## Conservation Area Advisory Committee

WA/73/18/HH

Front porch & enclosure for wood burner. This application affects the character & appearance of the Walberton Village Conservation Area.

2 Parsons Walk Walberton BN18 0PA

PROPOSED ELEVATIONS

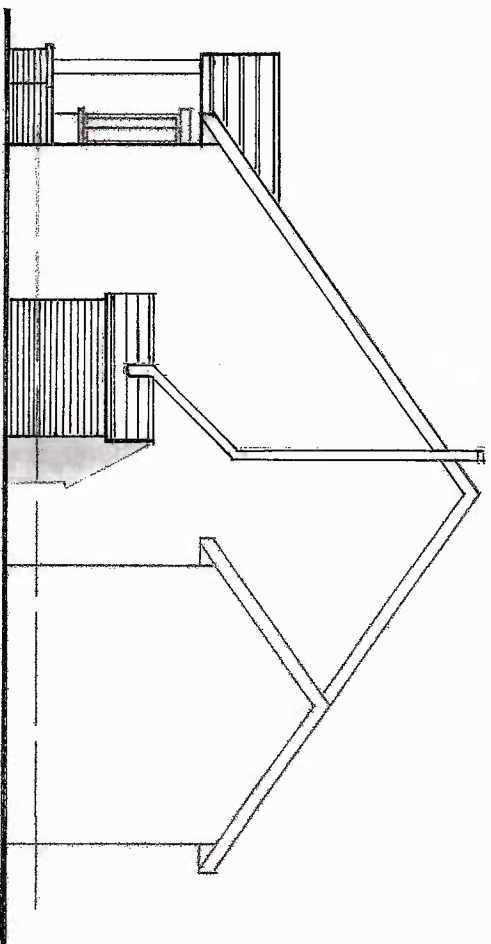
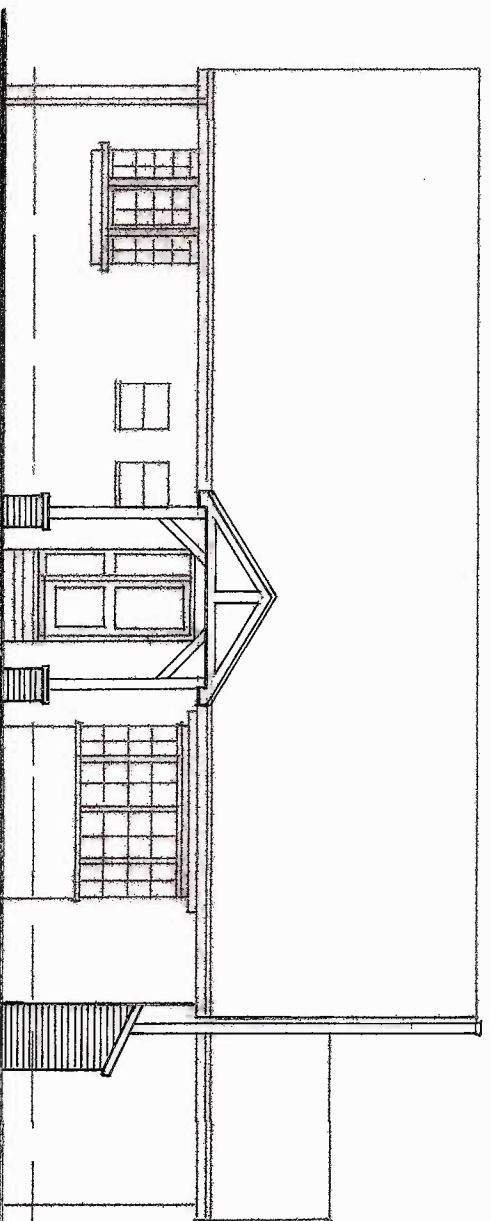
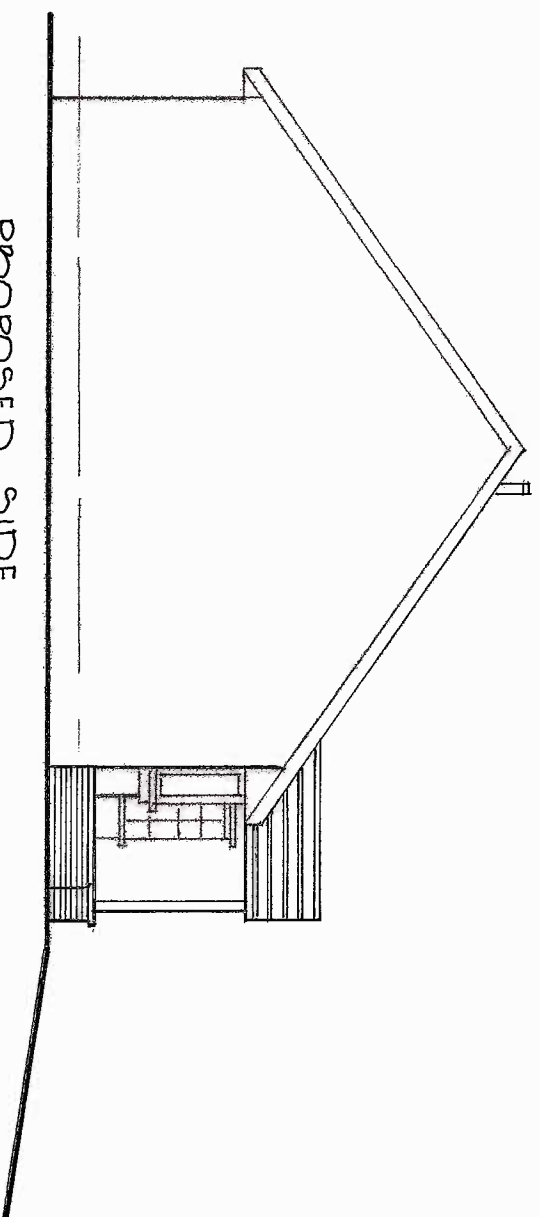
Please detail of materials in the extension and  
details of the chimney and its crown to be submitted
